Engineers Comments Regarding Surface Water Drainage

Application Reference:	WA/20/26/PL	Reviewer Reference:	EXT2/02
Planning Officer:	Harry Chalk	Date of Review:	06/05/26
Site Name:	Land to the South of The Black Horse Pub Binsted Farm Binsted Lane BN18 0LP		
Application Description:	Siting of 6 No. glamping pods with associated structures, access, car parking and landscaping (part retrospective). This application may affect the setting of a listed building and is in CIL Zone 3 (Zero Rated) as other development.		
Assessment Number:	1

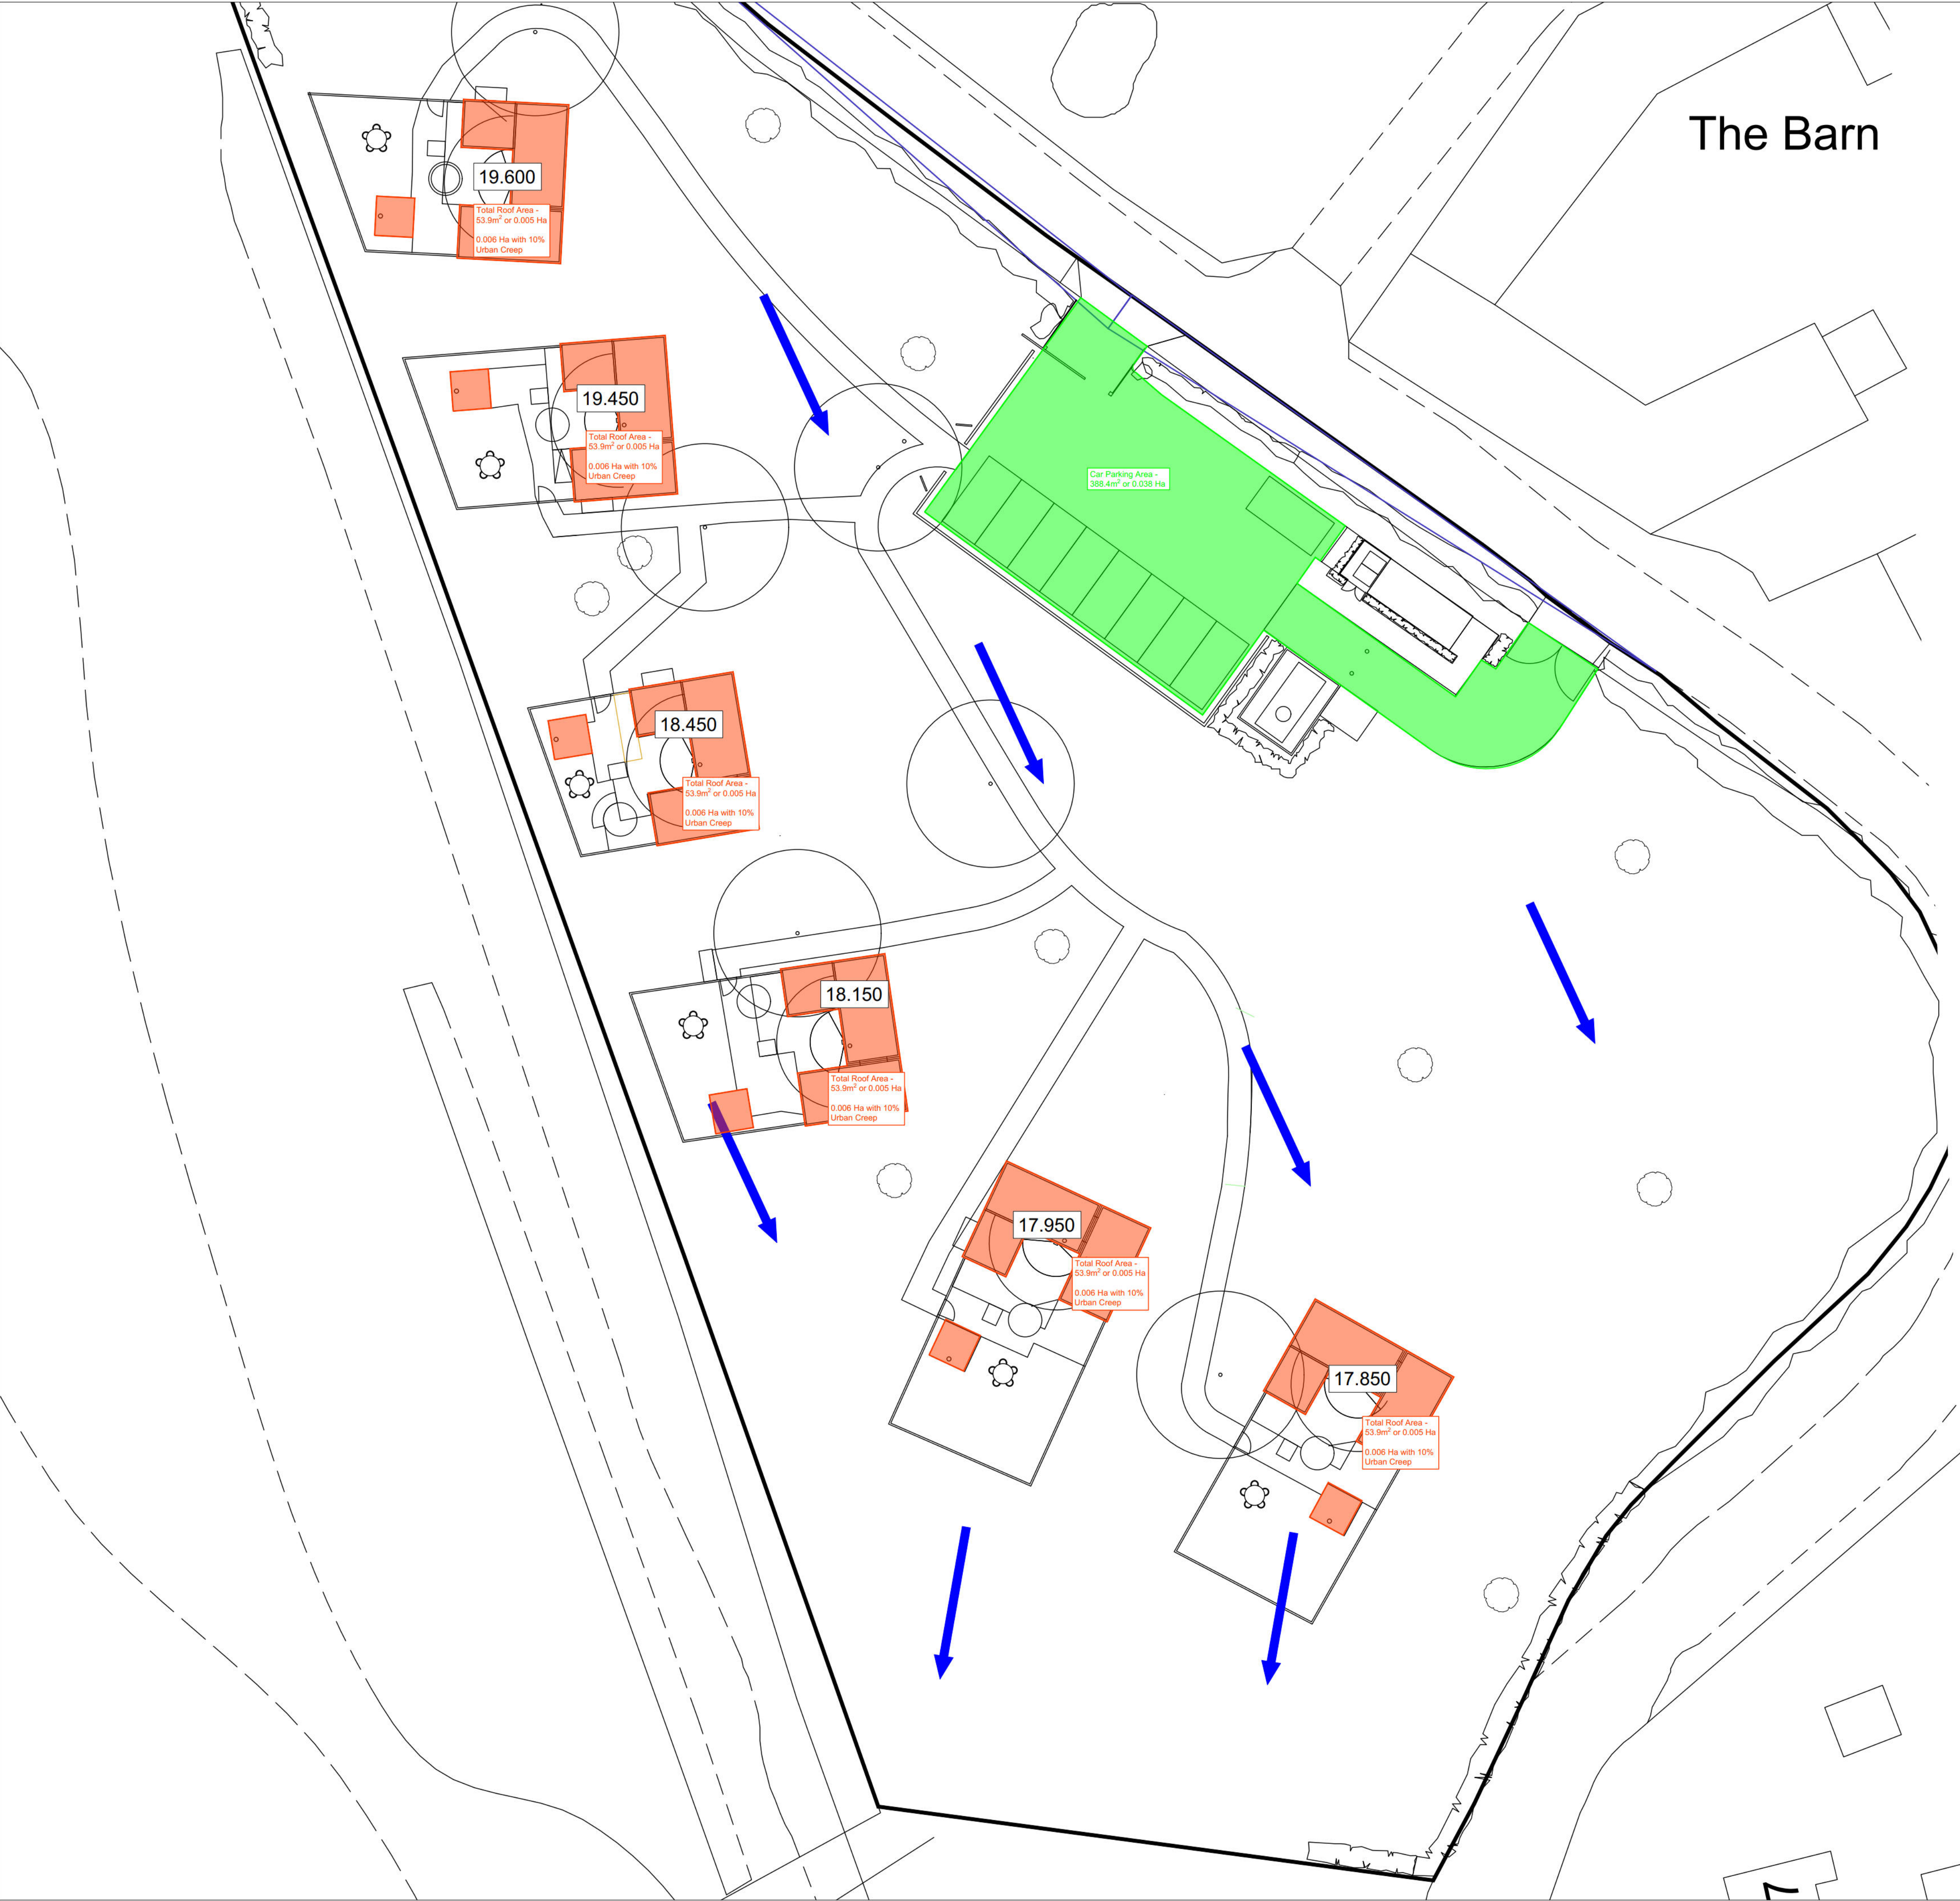
- 0.1. The submitted information does not demonstrate that the 7 Standards have been complied with for the reasons set out under 1 to 7 below.
- 0.2. The proposed drainage layout does not include existing levels and the information provided regarding proposed levels is limited. It is not possible to assess if the proposed drainage system is suitable for the existing topography.

- 0.3. No information regarding the size of the existing watercourse has been provided nor have the proposed connection details.
- 0.4. Sections through the proposed SuDS features and the outfall have not been provided and it is unclear how the proposed permeable paving will connect to the piped section of the proposed drainage system.

- 1.7. Rainwater harvesting is proposed but details relating to the sizing are not included and the intended use for the harvested water is not clear. The drawing refers to "garden rainwater harvesting system" and the report states "for use within the units". It should be demonstrated that the volume of water that is collected is appropriate for the intended use, bearing in mind the seasonal use of the development.

- 3.2. It is noted that the orifice flow control has a diameter of 31mm. Whilst this will need to be reviewed once the correct discharge rate has been established, the risk of a blockage of the flow control must be considered and mitigated.

- 3.3. The exceedance flow routing appears to pass over the area where the proposed basin is located. Information should be provided demonstrating that exceedance flows (including from elsewhere) are conveyed safely around or through the site without compromising the SuDS system.

BLUE ARROWS SHOW ROUTE OF EXCEEDANCE FLOWS FROM PROJECTED POINTS OF EMERGENCE TOWARDS DIRECTION OF FALL.

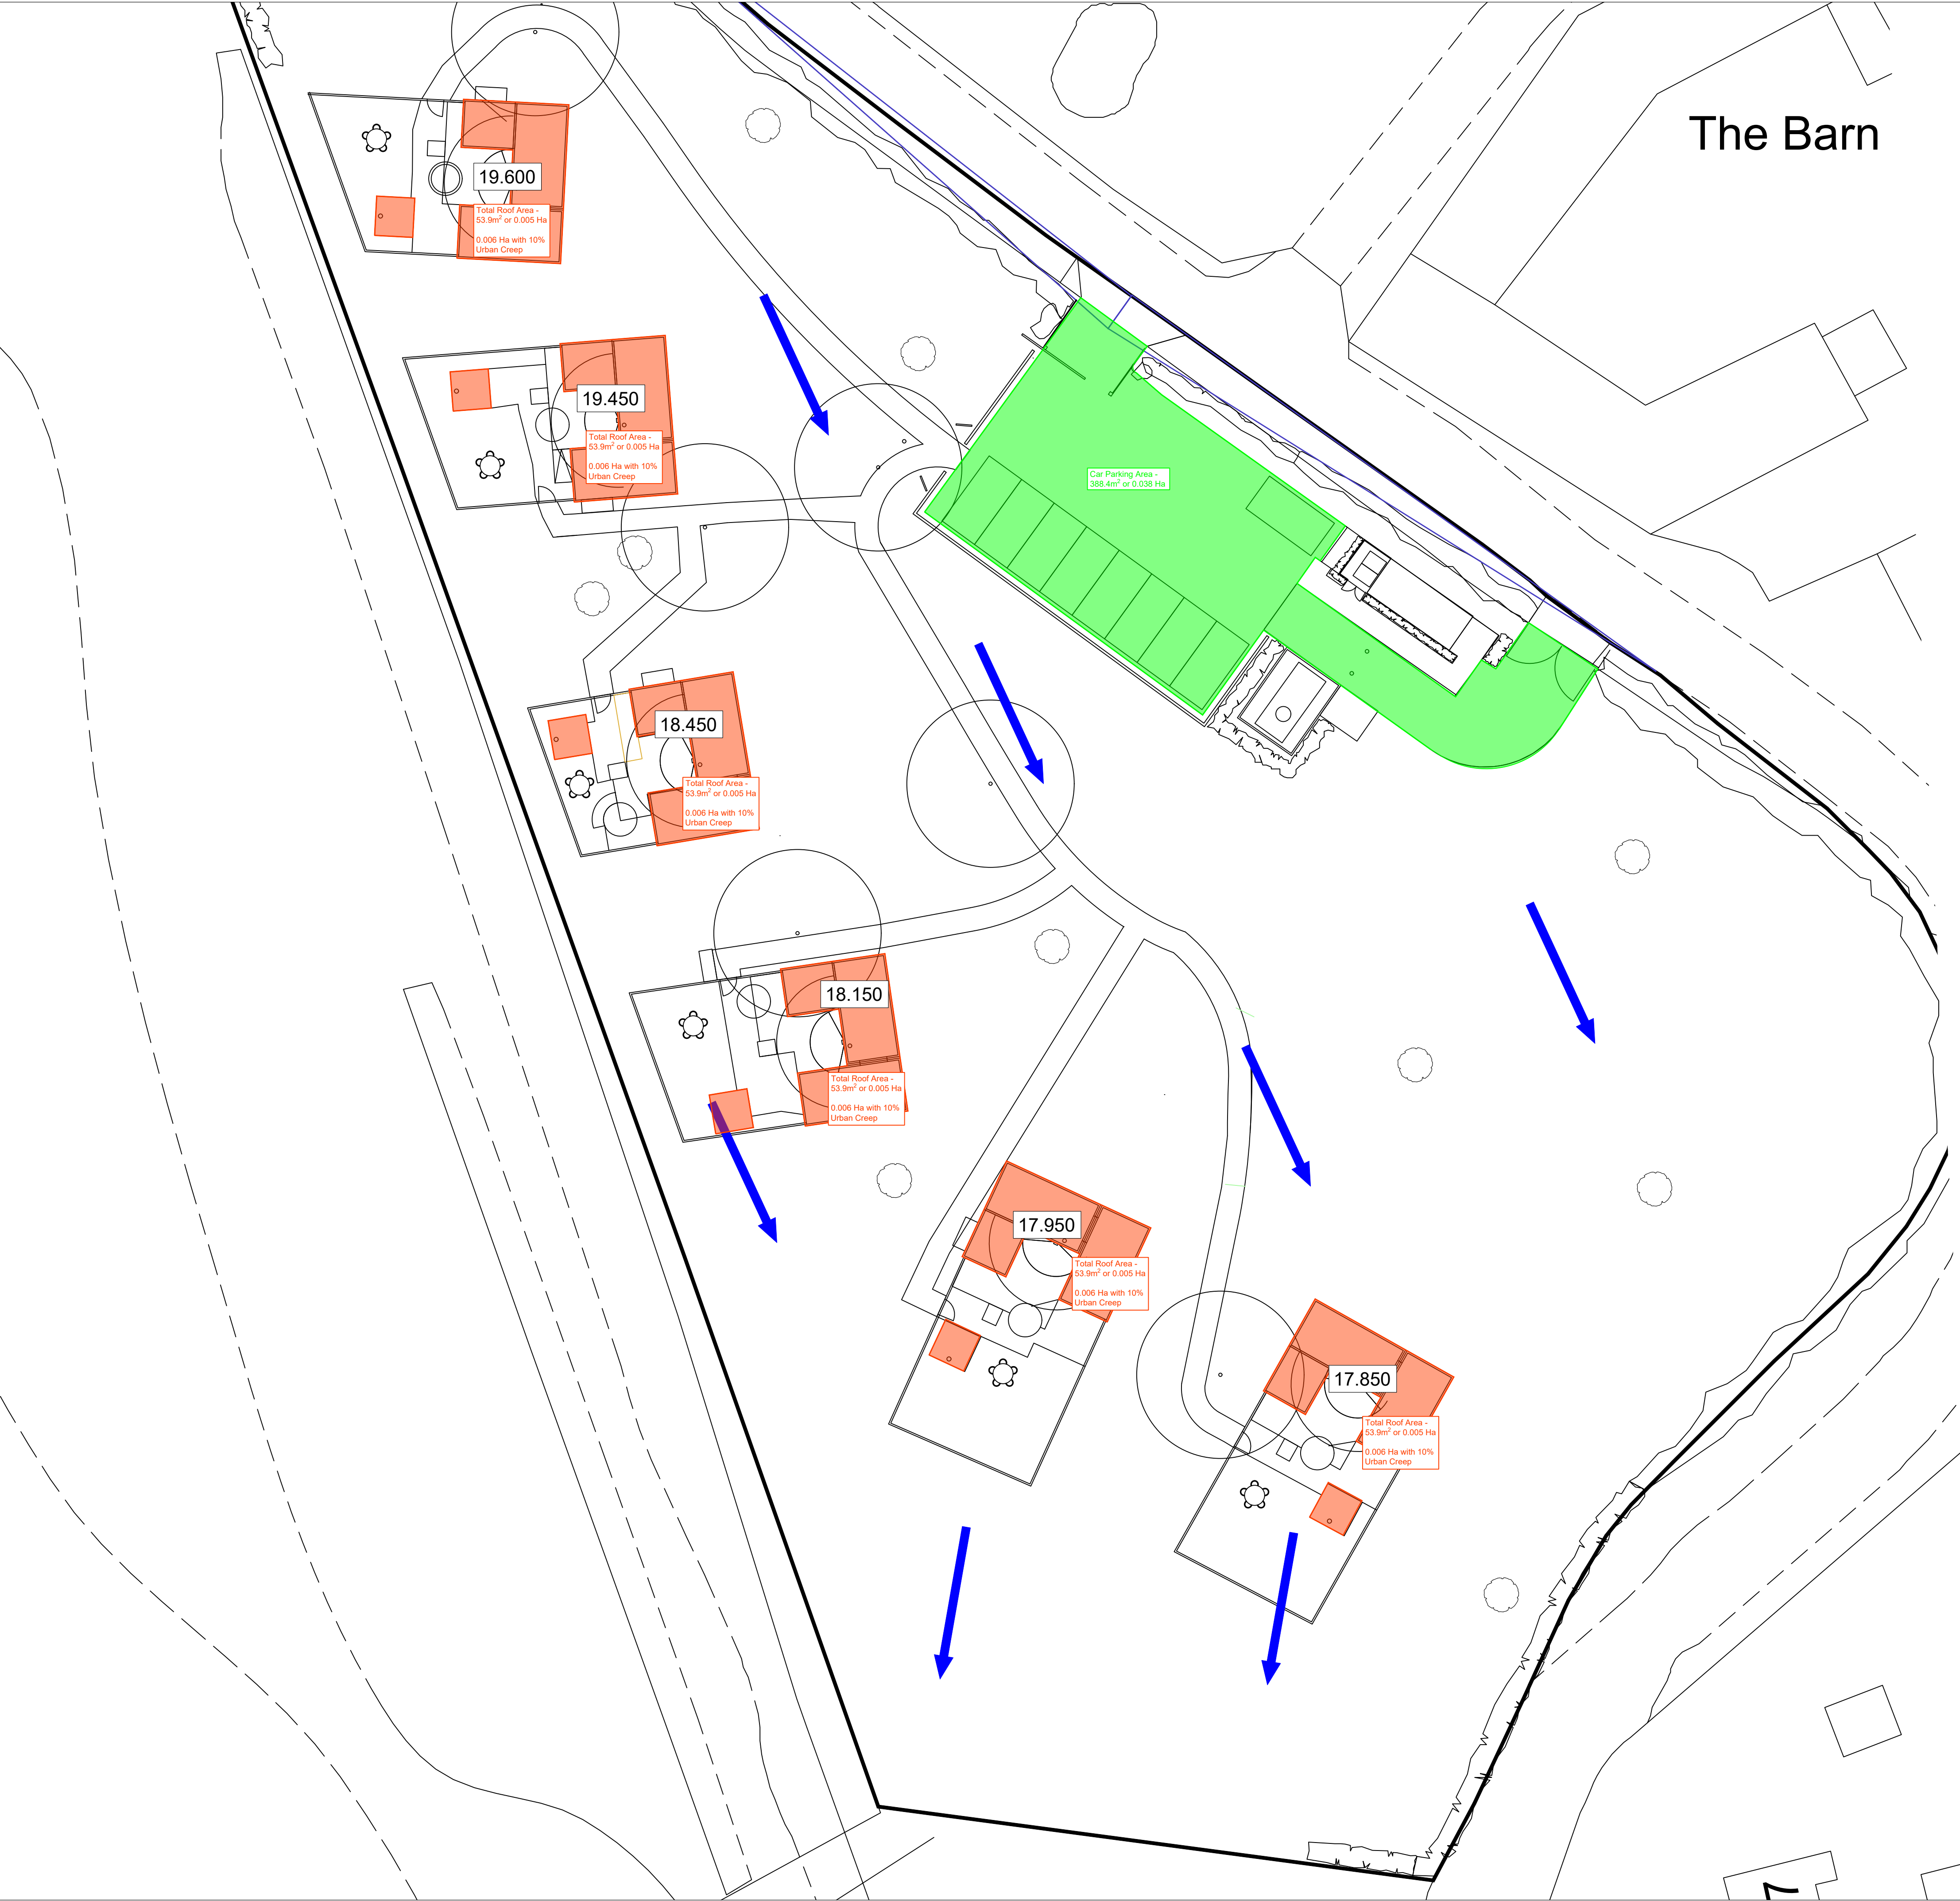
- 0.7. CGS Drawing 401 refers to an infiltration basin, this conflicts with the drainage strategy.
